AB/73/09

S/AR/AB/2009/73

Extension to kitchen at ground floor
15 Kirdford Road, Arundel BN18 9EE
AB/73/09

PLAN SHOWING DRAIN + FOUNDATION DETAILS

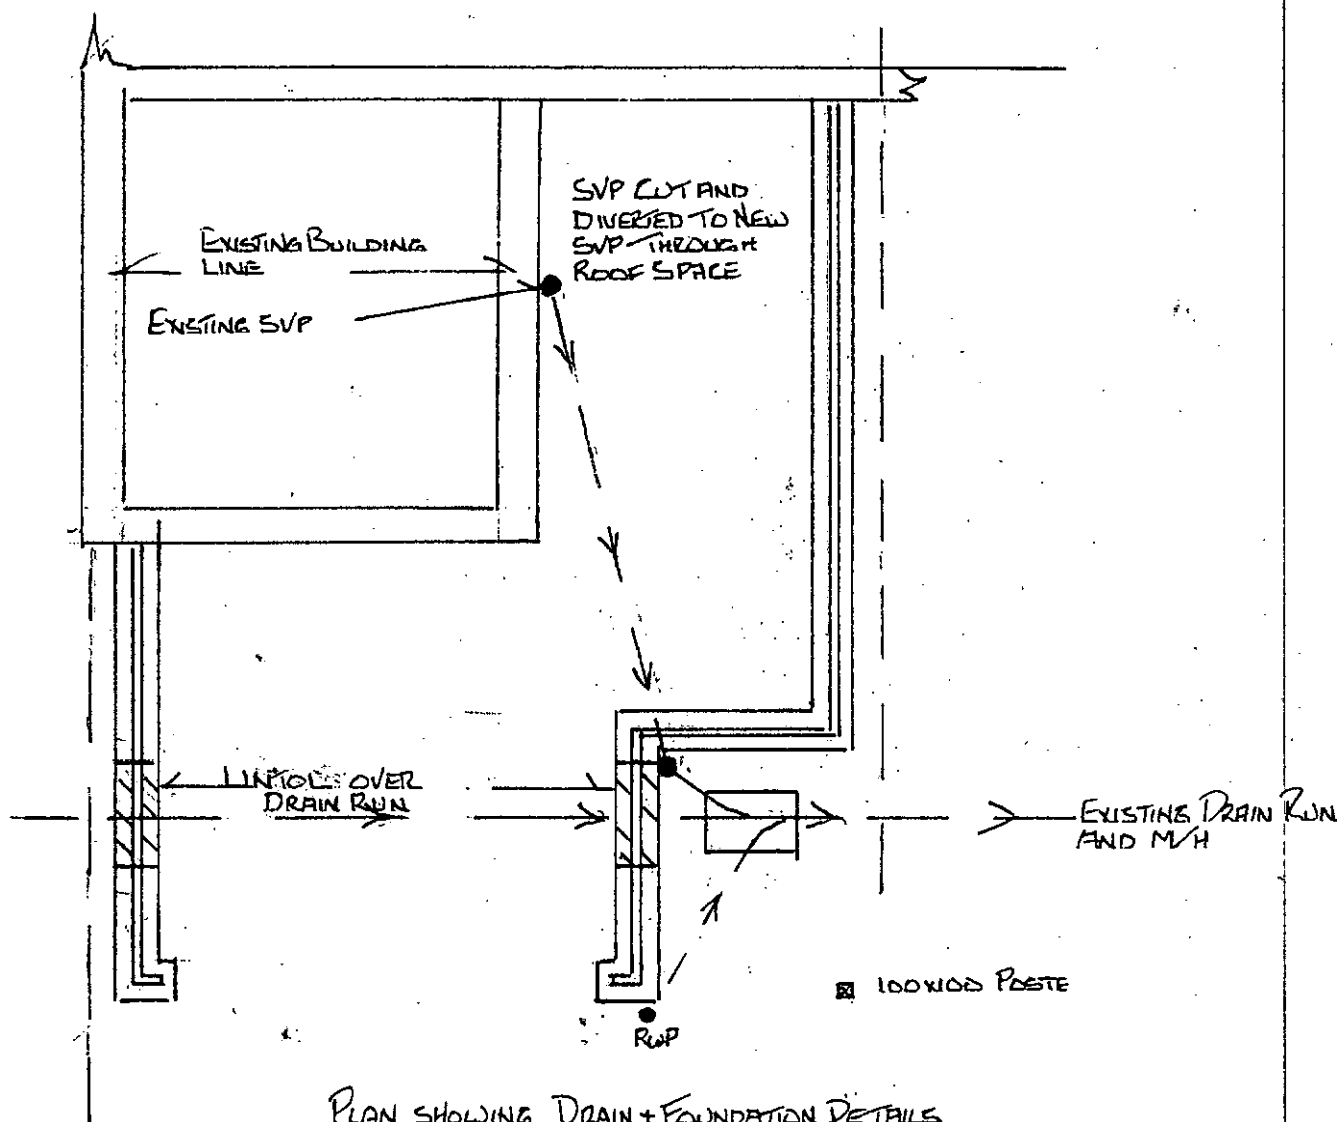
The applicant has not stated details of the proposed means of disposal of surface water from the site. This should not involve disposal to a public foul sewer.

Please find attached a plan of the sewer records showing the approximate position of a public sewer in the vicinity of the site. The exact position of the public sewers must be determined on site by the applicant before the layout of the proposed development is finalised

1. No construction works parallel to the sewer within 500mm (in plan).
2. Where within three metres, foundations to be taken down 150mm below the invert level.
3. Sewer to be bridged by PCC lintel to Building Control specifications (where applicable).
4. Replacement work to be carried out in approved material (not PVCu).
5. No internal public manhole.

We request that should this application receive planning approval, the following condition is attached to the consent: "Construction of the development shall not commence until details of the proposed means of surface water disposal have been submitted to, and approved by, the Local Planning Authority in consultation with Southern Water."
